**Consultation Response from KC,
Lead Local Flood Authority**

2025/93500 adj, 208, Yew Tree Road, Birchencliffe, Huddersfield, HD2 2EQ

Discharge of details reserved by conditions 6 (Phase II Intrusive Site Investigation Report), 7 (Remediation Strategy), 14 (Temporary drainage), 16 (drainage strategy, 17 (drainage attenuation), 23 (construction traffic), 26 (EVC) on previous permission 2018/90151 for outline application for erection of residential development

**Date Responded: 22nd March 2026
Responding Officer: Paul Farndale
Responding Ref: 2**

| Rev | Details | Date | Drawn | Chk. |
|--------------------------------------|---------|------|-------|------|
| Surface Water Management plan | | | | |

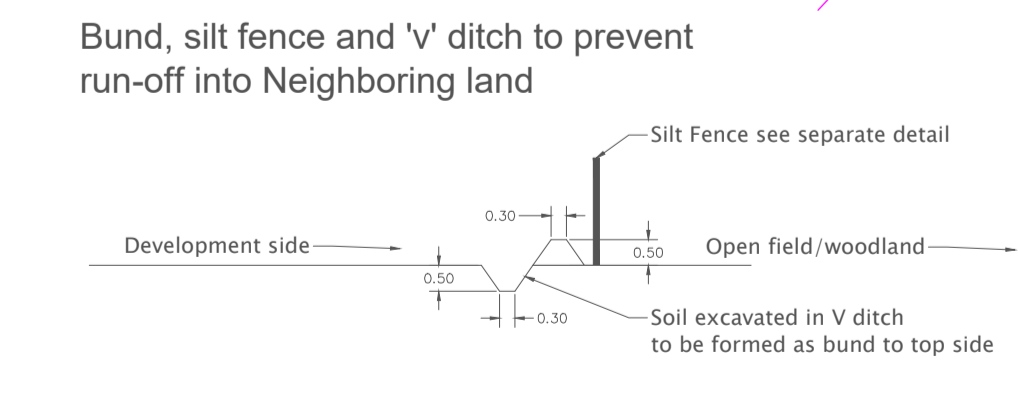
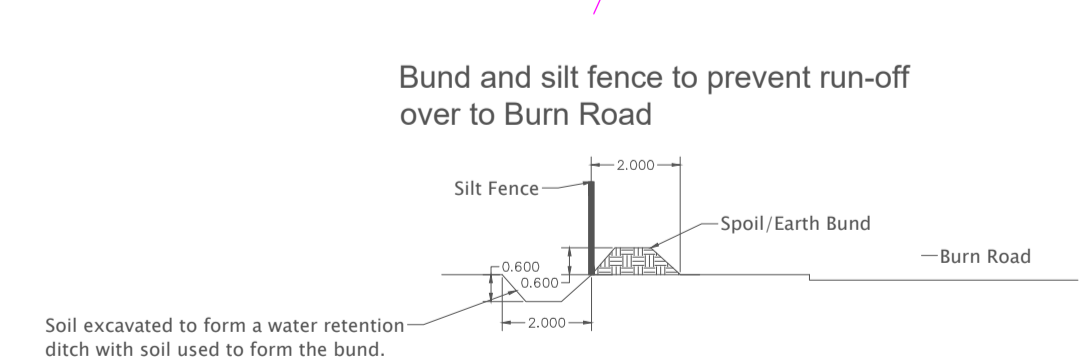
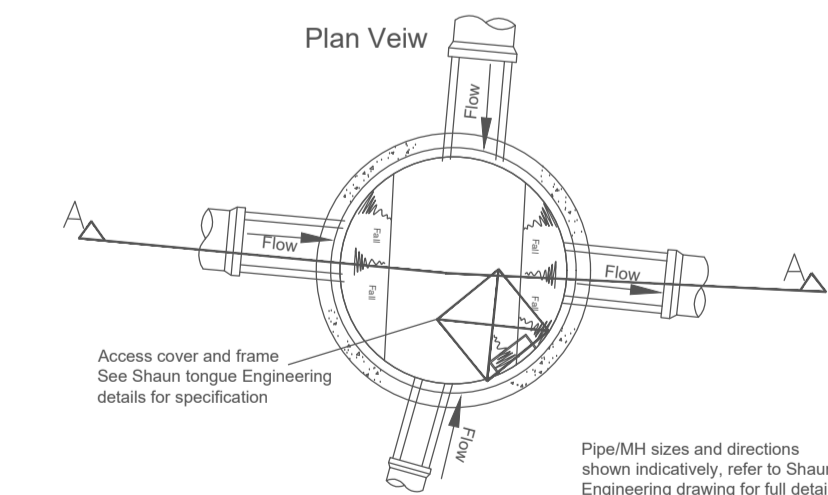
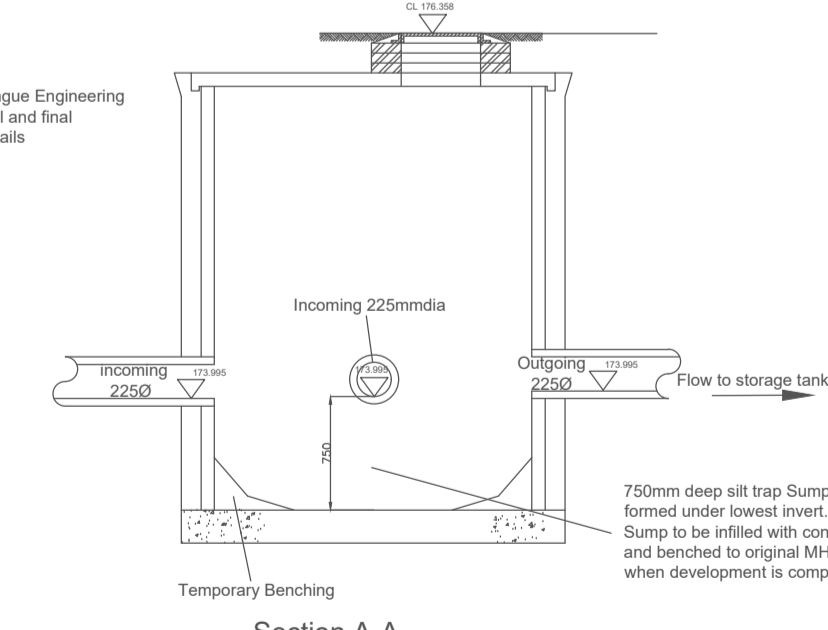
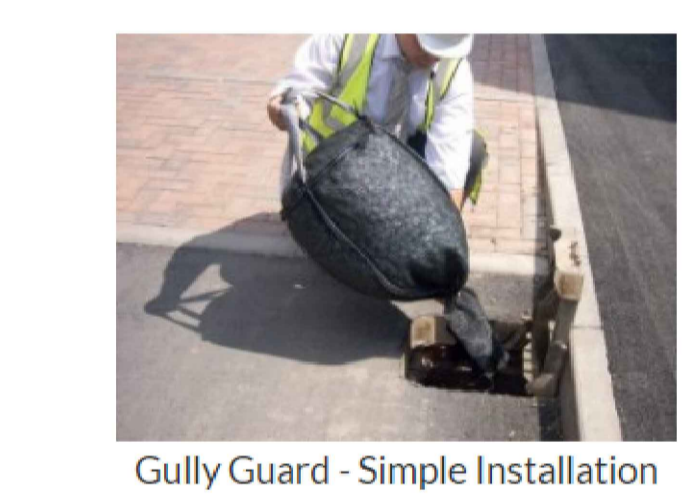
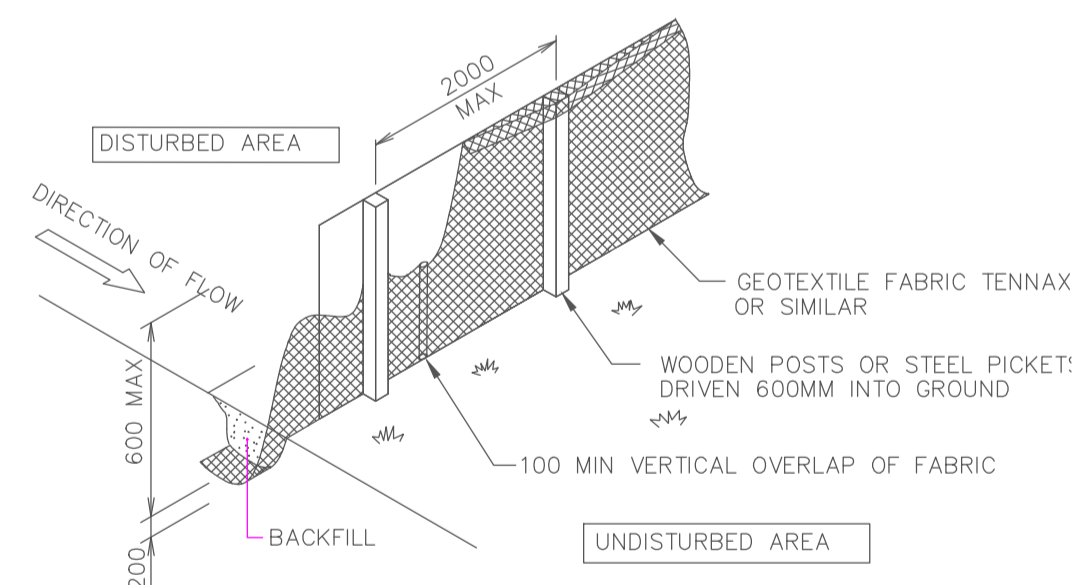
Plans and narrative for 'temporary' drainage are accepted as proportionate for this site.

We recommend that this condition be discharged.

**DRAWING TITLE:** NEWETT HOMES  
YEW TREE ROAD, BIRCHENCLIFFE  
2.0m DEEP ATTENUATION TANK  
BASE LAYOUT

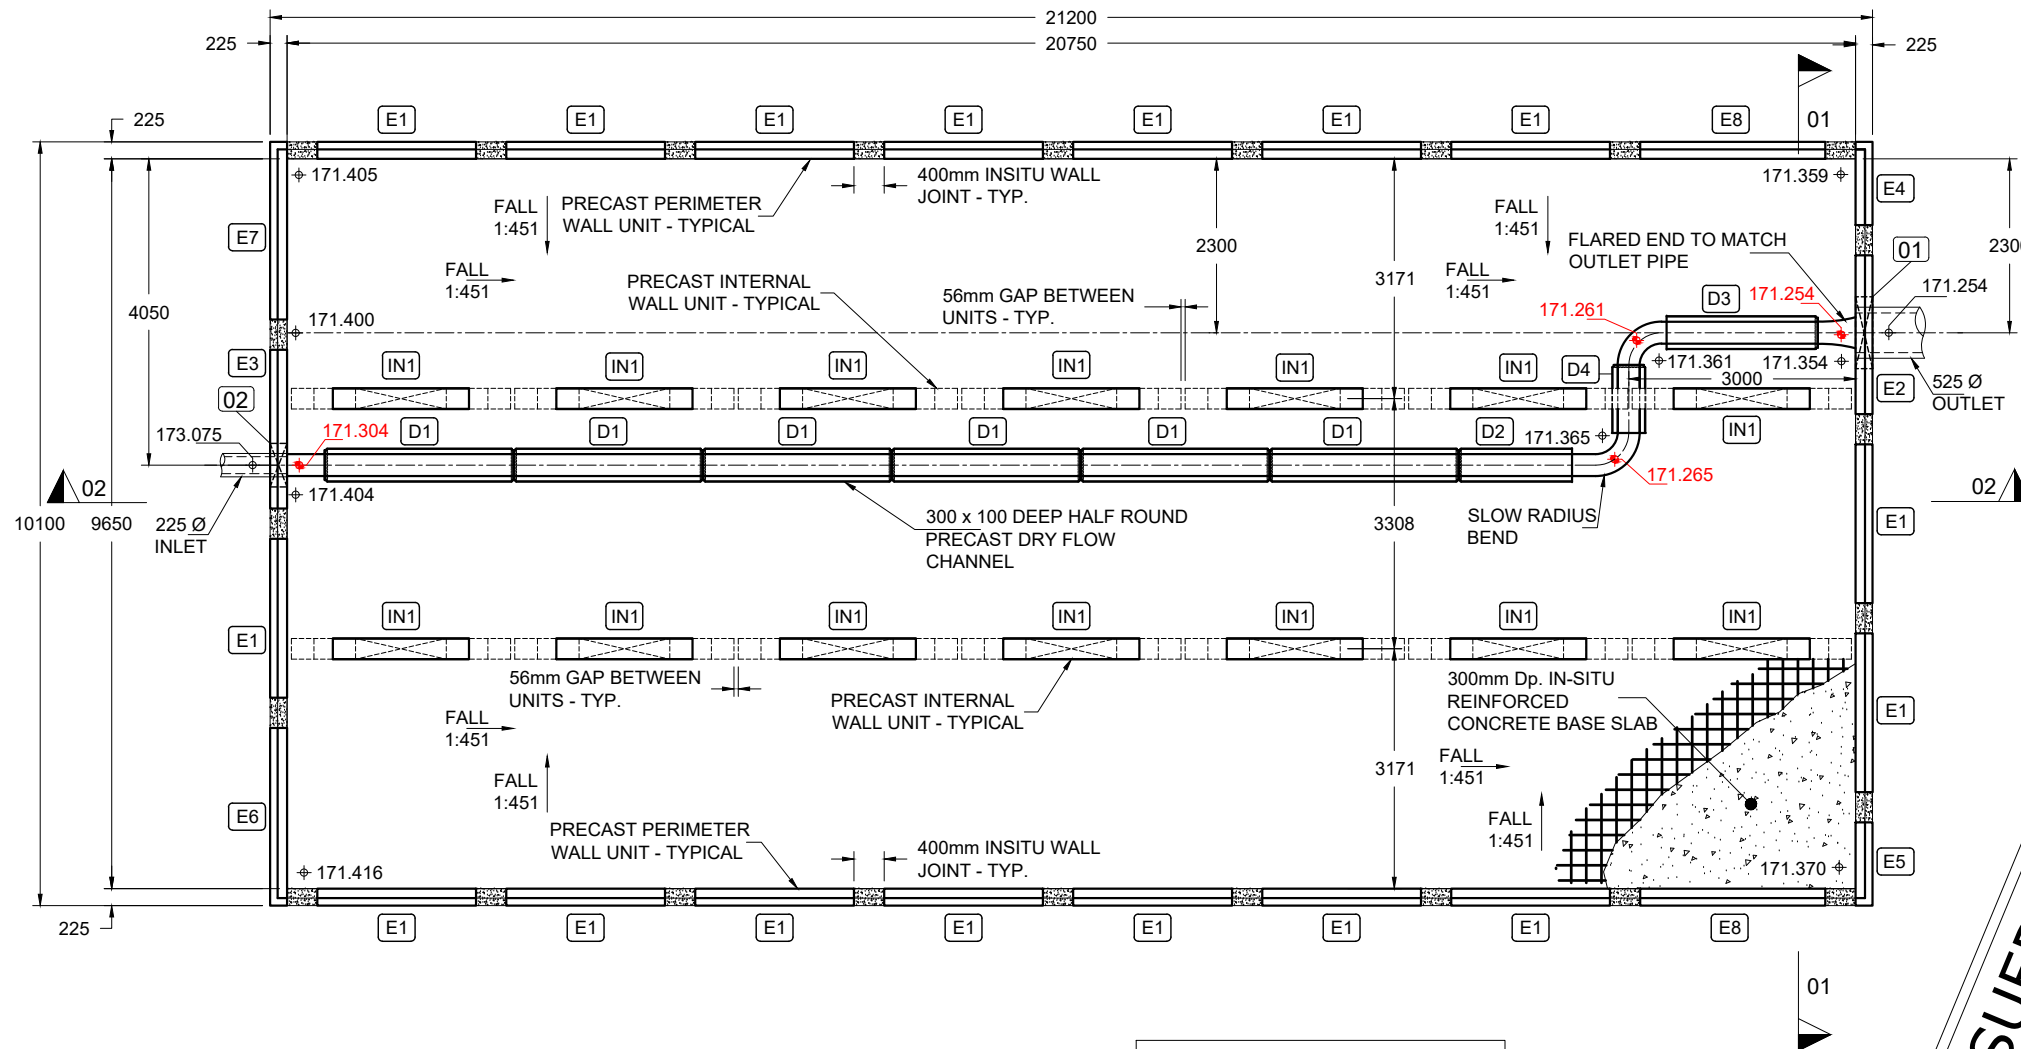
Tank details are supplied from Carlow and accepted. A drainage plan reflects the volume involved. However, surface water hydraulic analysis has the tank, marked as '-1' for diameter but statistical reference for the design of '-1' on subsequent pages is missing.
